Judge Orr RV Park and Storage, PPR-18-040

Please accept the following revised comments from El Paso County Public Health (ECPH) regarding the project referenced above:

- The Entech Engineering, Inc., Onsite Wastewater Treatment System Design, Job #160533, dated 21May2018, is proposed for wastewater treatment for the RV park. The following comments must be addressed prior to a New OWTS Permit being issued by El Paso County Public Health:

8

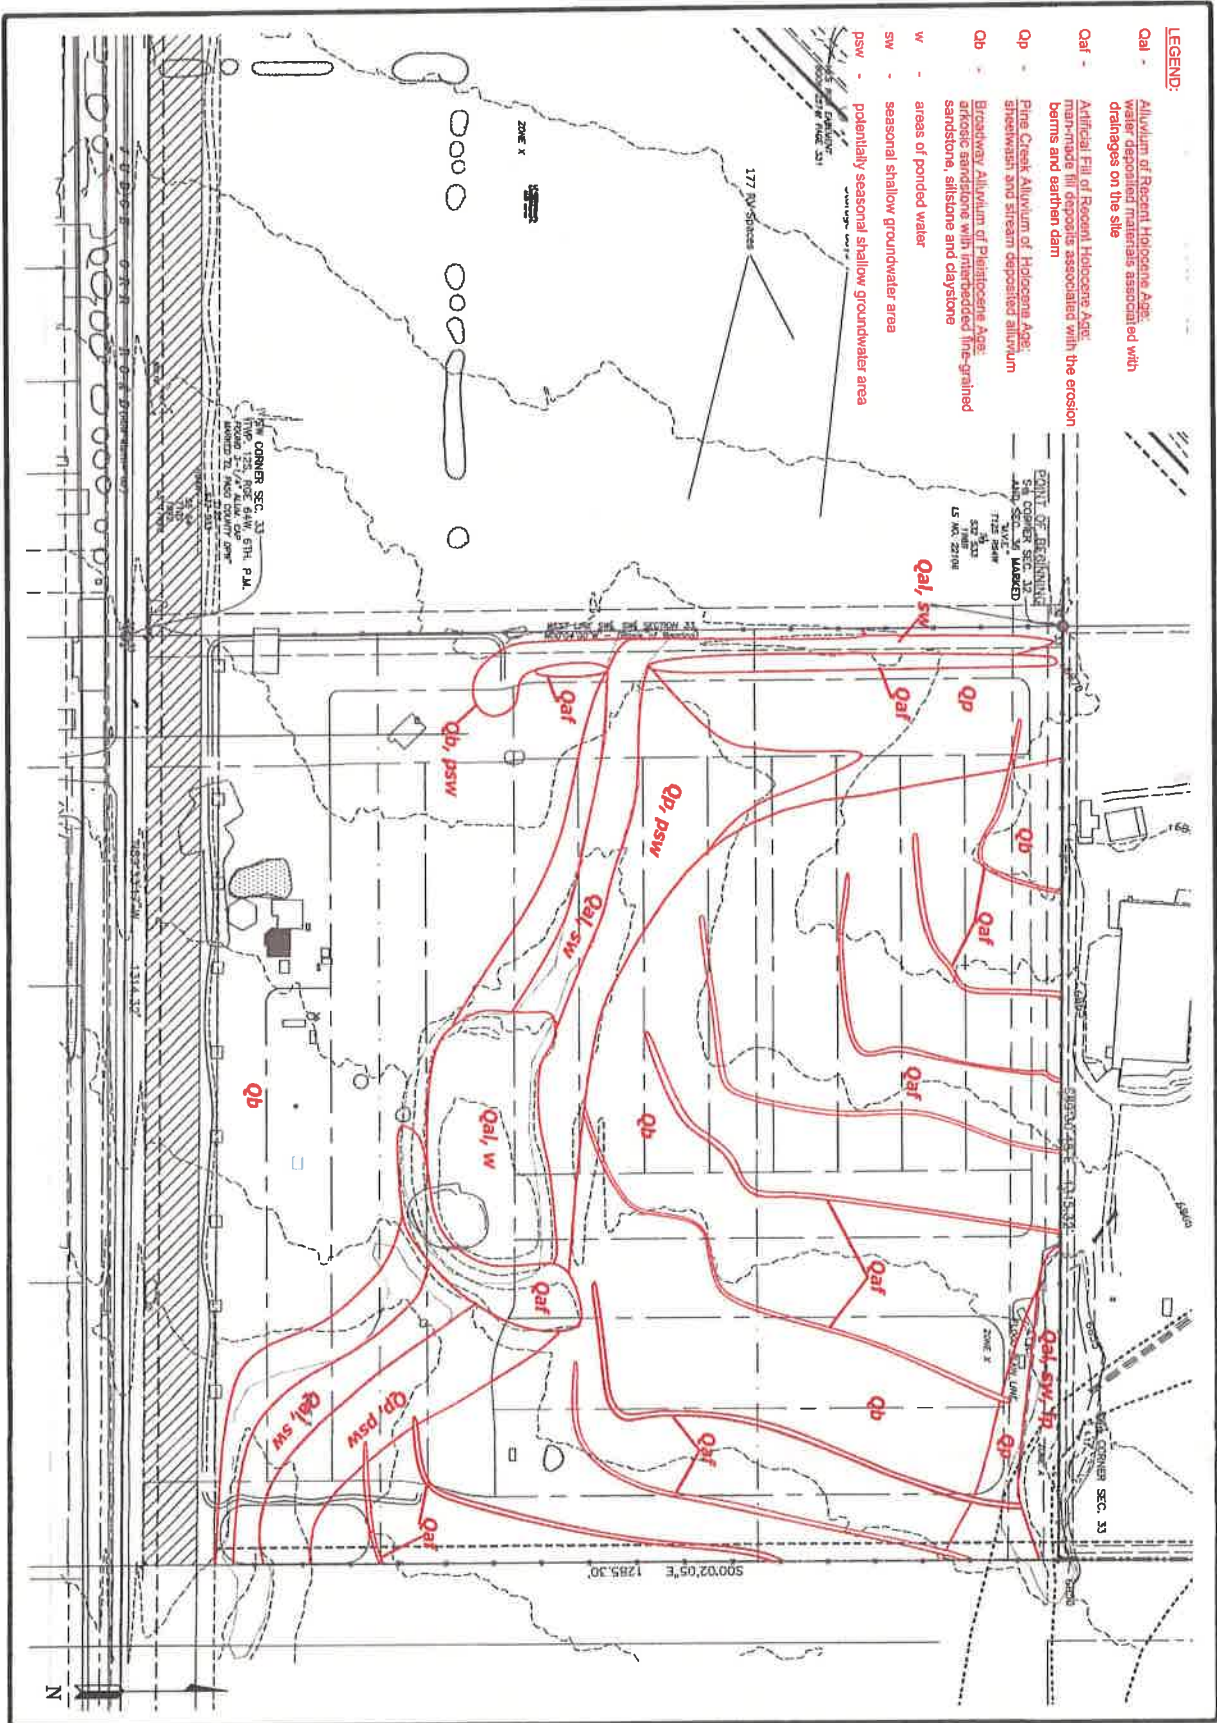
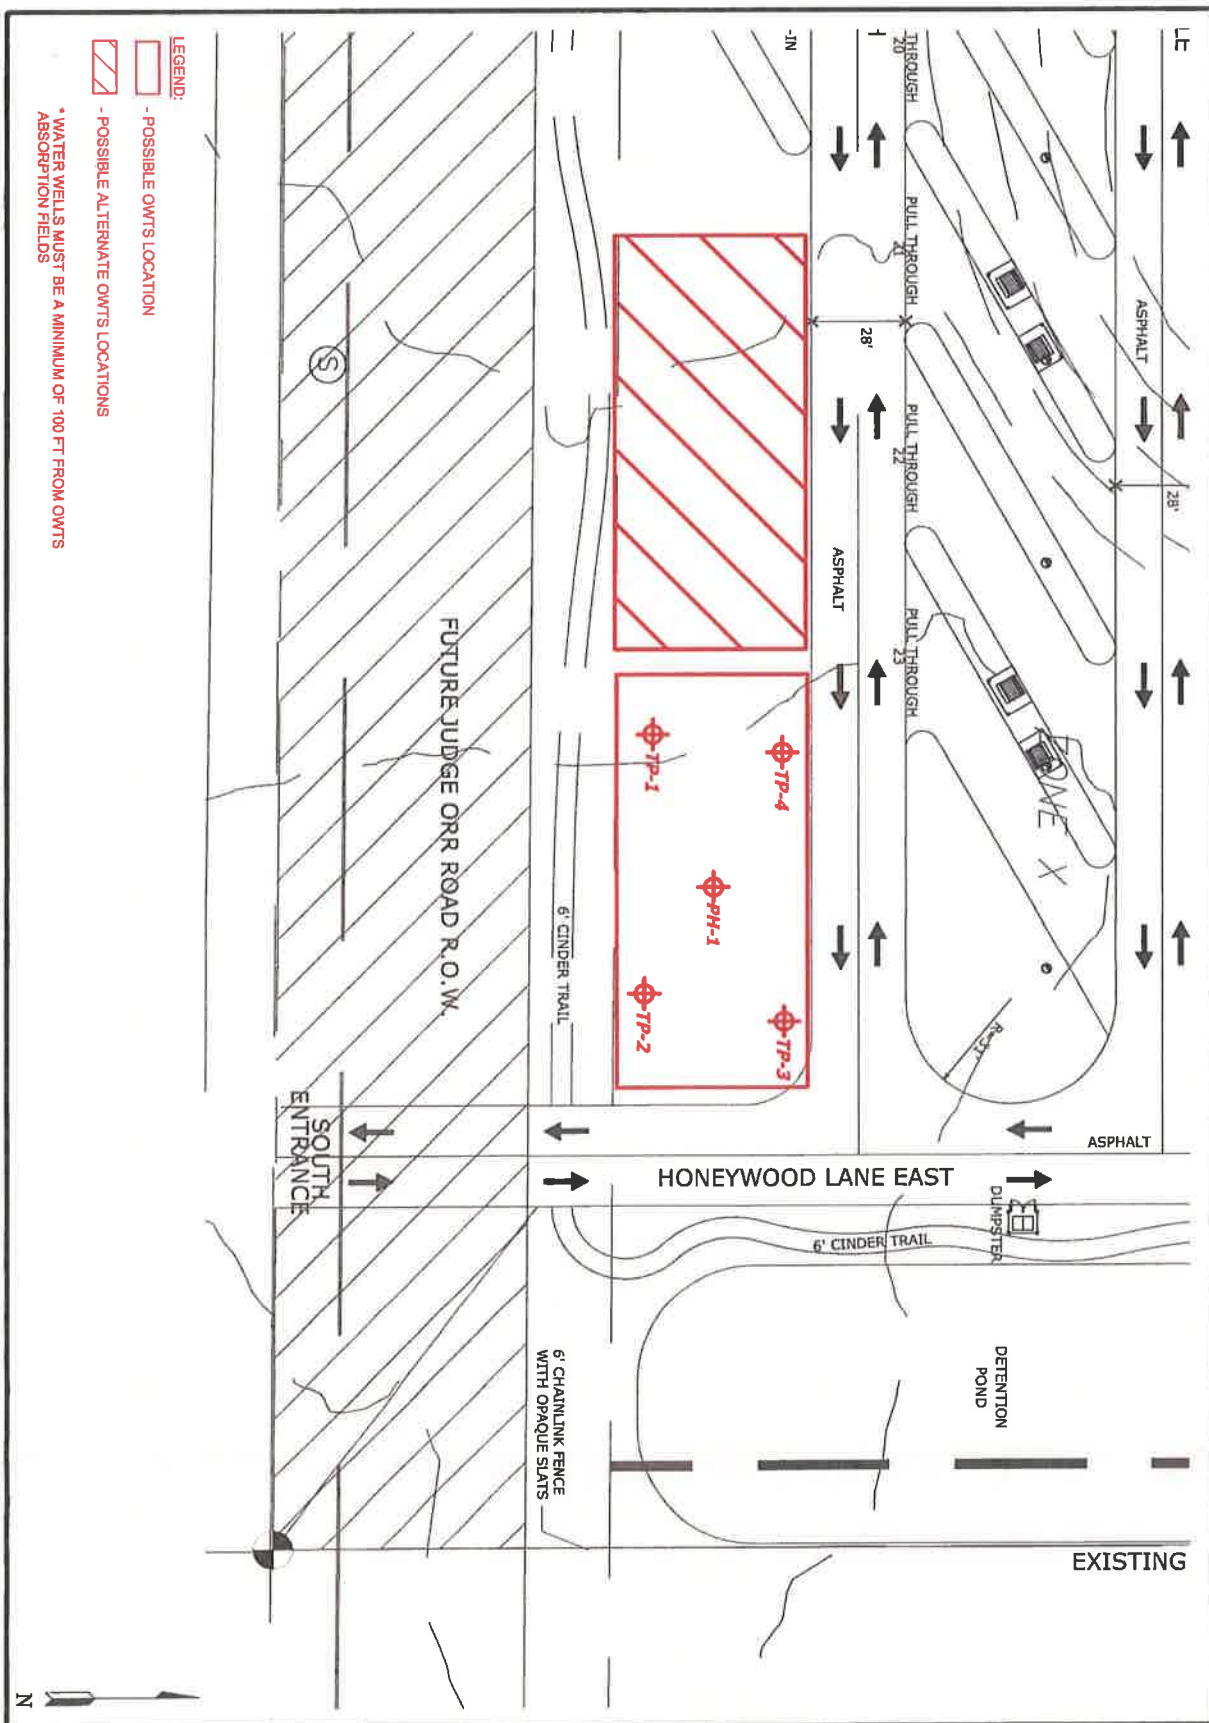
- The Zones of Influence as outlined in CDPHE Water Quality Policy #6 for the soil treatment areas and the existing and proposed well must be mapped and included as a part of the permit application.

- The OWTS soil treatment area (STA) secondary sites and the associated Zones of Influence must also be included with the permit application.
 - The OWTS Regulations in effect at the time of the permit application will be used by El Paso County Public Health for reviewing the application.
